**Consultation Response from KC,
 Conservation and Design**
2021/94280 land at, Lady Ann Road, Soothill, Batley, WF17 0PY
Erection of 67 dwellings with associated works
Date Responded: 10/02/22 Responding Officer: NRG Responding Ref: HS74
1. Context.

PROPOSED SITE PLAN

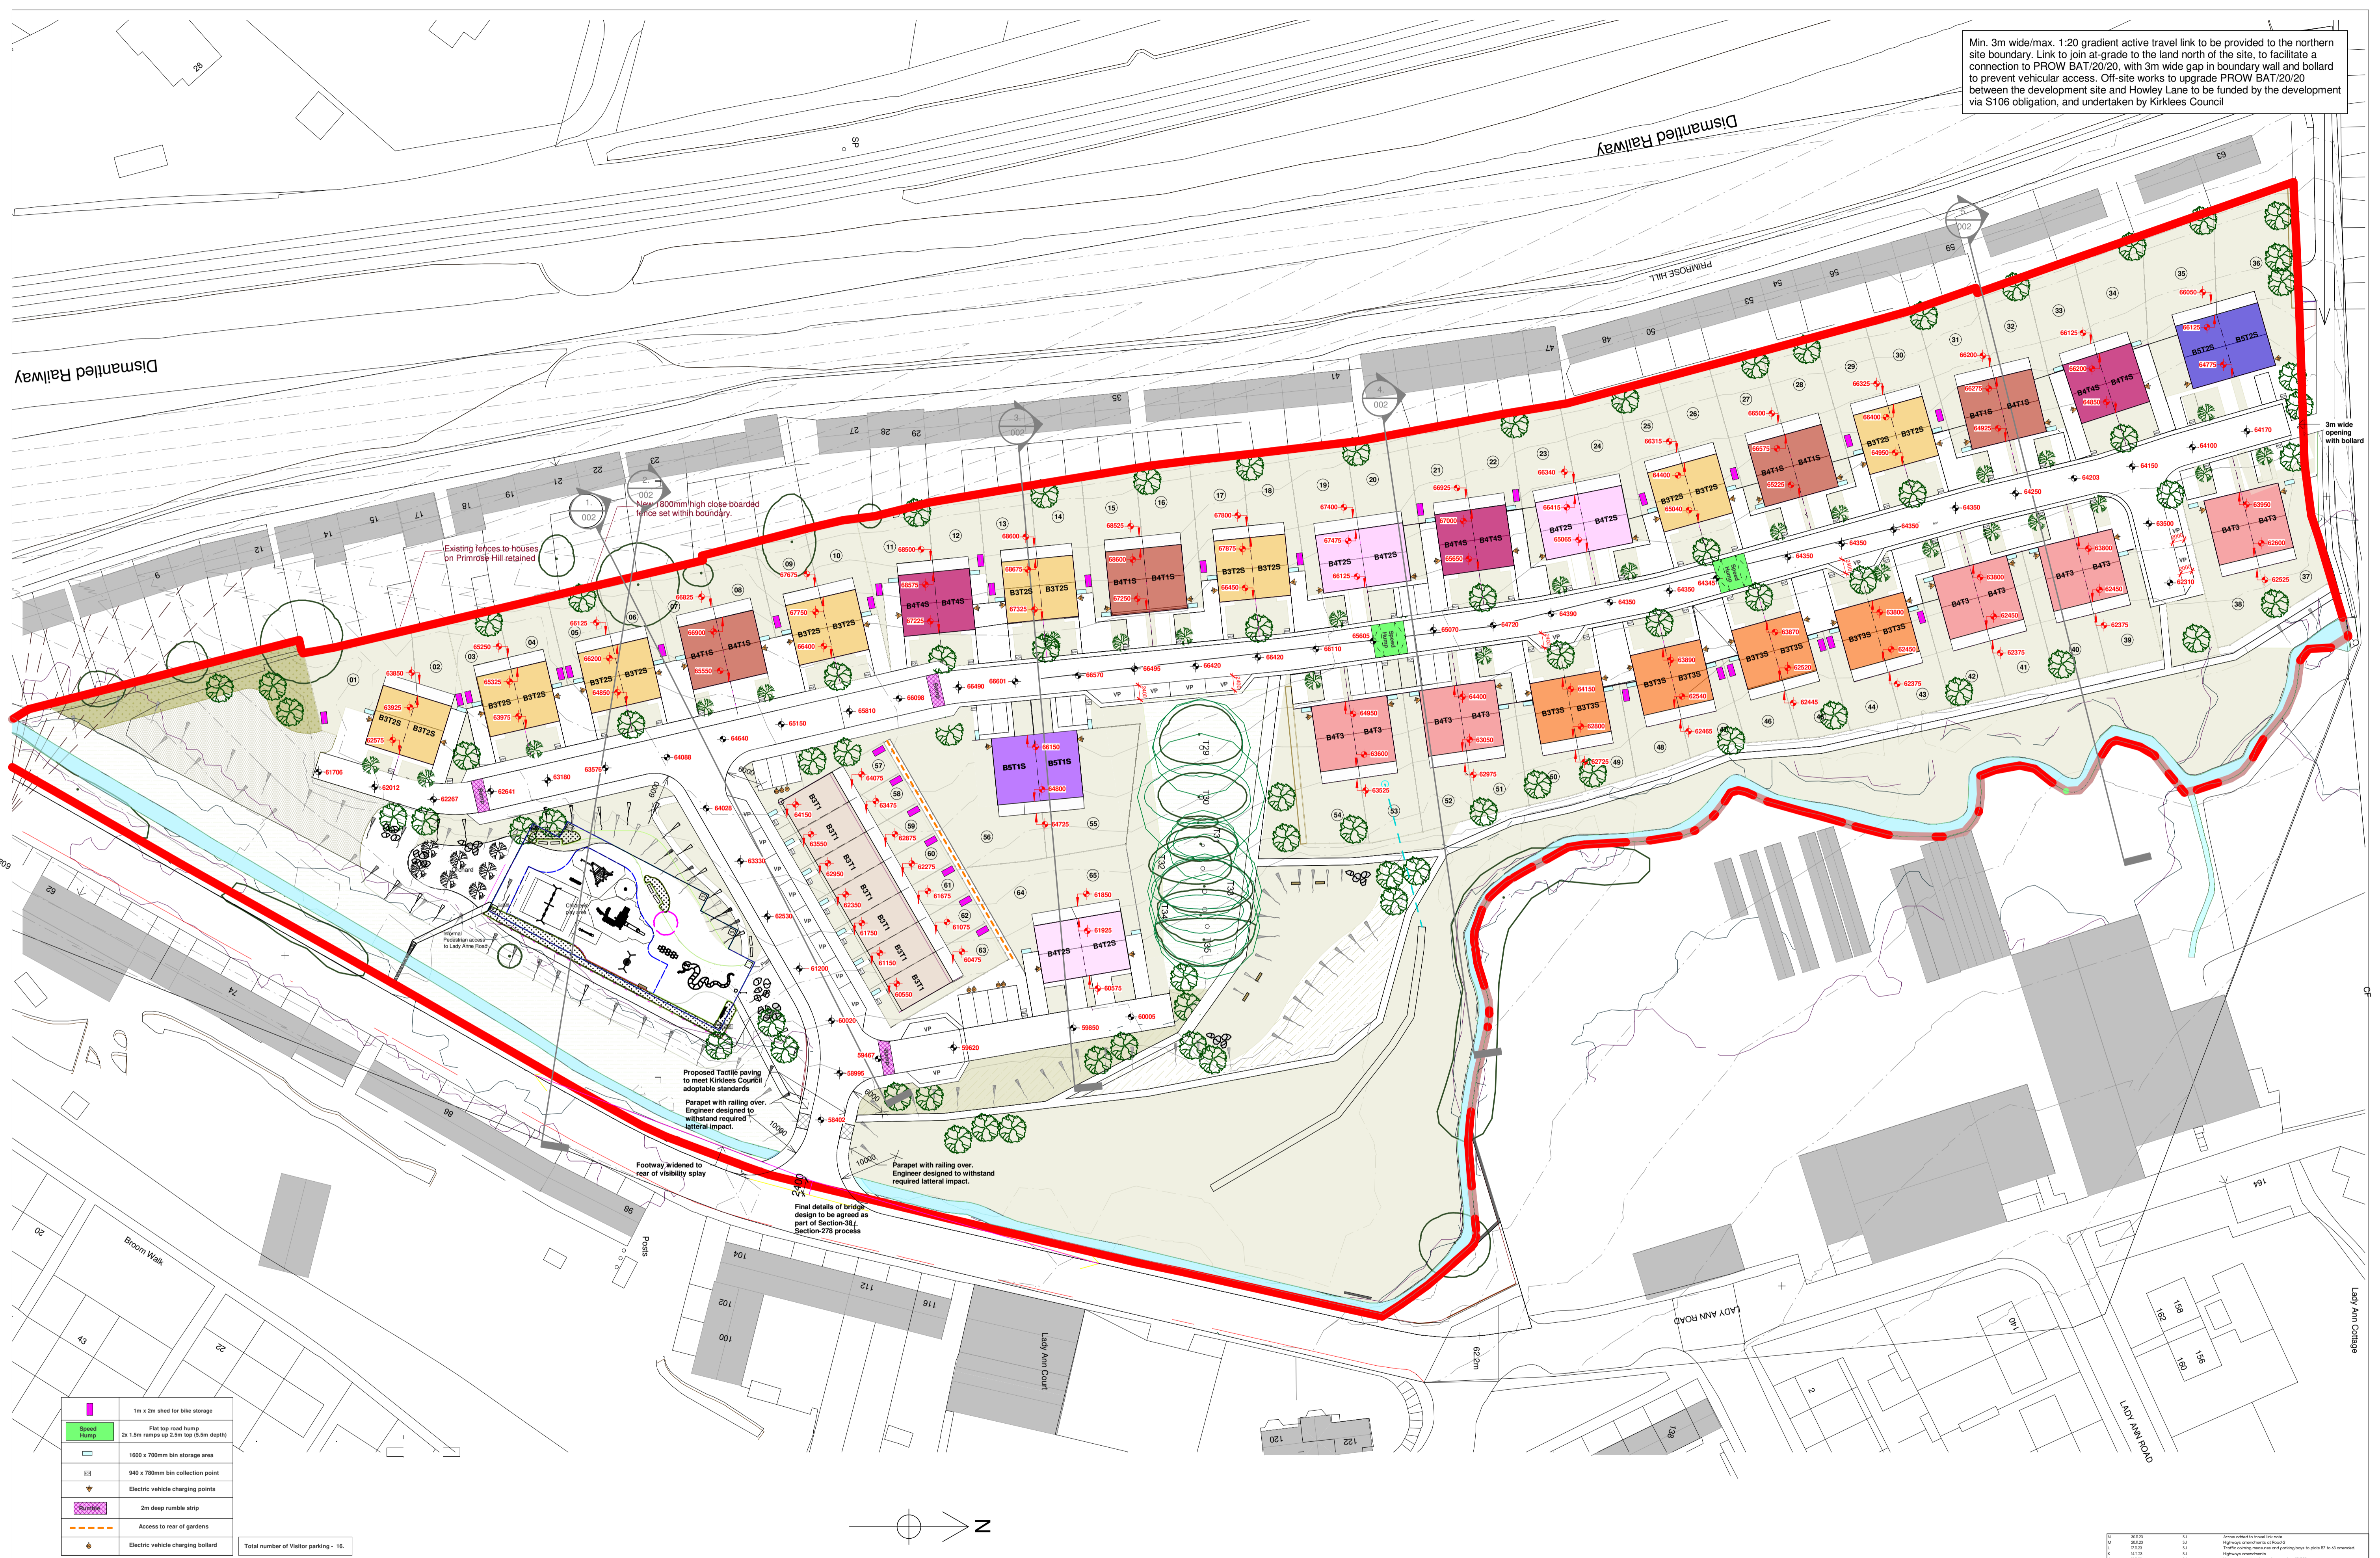
- 2.1 The current ‘Proposed Site Plan’ (Self Architects Drg:10703-SELF-P-XX-DR-A-002) appears to be essentially the same as that previously refused consent (2019/92462 for 71 dwellings) and fails to address the key concerns which led to its refusal or respond to the distinctive form of its context. The current site plan states that it proposes 67 Dwellings based on an approximate site area of 3.47 hectares, contrary to the description in the Local Plan allocation, suggesting an artificially low Density of 19.14 units per hectare. As the developable area is no more than 2.77 ha (Local Plan ref: HS74), 67 units would amount to a density of 24.18 dwellings per hectare.
- 2.2 Comments and concerns were previously raised with regard to the potentially adverse impact of the previous application submitted for this site (Ref: 2020/93071) which was for 71 units but

was withdrawn. The current application is essentially the same layout with a reduction of 4 units which were previously located on the site of the area of TPO protected trees (ref: 72/91/g1). The current proposal for 67 units indicates that it would retain the protected tree group, although this is tightly enclosed by the proposed adjacent dwellings (units 57, 54, 70, and 67) calling into question the future management of the tree group. The current scheme also now includes an additional section of road area to accommodate a turning-head road projecting into the 'Wetland Habitat' area, with additional engineering work and an apparent loss of tree planting opportunities.

- 2.3 The proposed road layout continues to present an apparently insular grouping with token reference to the wider landscape character or the form of its built and natural context. The proposed layout is dominated by the two cul-de-sacs, enclosed by fencing and hard surfaced parking areas. The layout does not accommodate any street trees, contrary to the requirements of the NPPF paragraph 131 and the Council's House Builders' Design Guide SPD. The scheme also would result in the loss of trees and scrub habitat, compromising the current informal use of the site.

- 2.4 The housing layout extends from the rear of extant properties to the west side of the site (fronting onto Primrose Hill) and projects towards Lady Ann Road. The residential units would appear disproportionately imposing on the context of the narrow, linear site, failing to respond to the character of the space. The undeveloped areas are essentially the flood-risk areas as wetland habitat and attenuation areas. The informal green-space areas at the northern end of the site are read as apparently 'left-over' spaces squeezed between back-garden fencing, the stream and the rear of the facing industrial units.

- 2.5 The proposed streetscape would be dominated by hard-surfaced parking areas, frontage refuse storage and a long 'shared surface' which would not be capable of being used for anything other than vehicles due to the lack of pavements and reliance on vehicles. The lack of an appropriate width to the 'shared highway' would negate any potential to integrate hedge or street trees. The proposed site layout would require the loss of trees and a failure to replace any tree and hedge planting. The proposal does not present (or could accommodate) any street-tree planting, despite the focus on detached and semi-detached housing, contrary to NPPF paragraph 131 and the adopted Housebuilder's Design Guide. The main streetscape would be dominated by a sterile, hard surfaces unsuitable for anything other than parking.

- 2.7 Therefore, given the existing character of the site as a greenspace the impact of the development should be tempered by:
 - a) avoiding the progression into the wetland resulting from units 63-67 and 70-71.

- b) redesigning the junction arrangement to create a single linear form with a widened streetscape.

- c) Reconsidering Unit 1 and the edge of the enclosure of the junction to accommodate units displaced from the current proposed site of 63-67 and 70-71.
- d) The road width should be eased by being widened to allow for appropriate pavements on pavements on both sides and accommodate street-tree planting. This could be achieved by easing the layout to the east.
- e) The rear of the properties should be landscape where they back onto the green space, while providing natural surveillance across the green-space/wetland.
- f) The connection to the right of way (BAT/20/20) needs to be fully detailed to avoid the creation of an apparent access through surface car-park and establish clear and managed public realm.
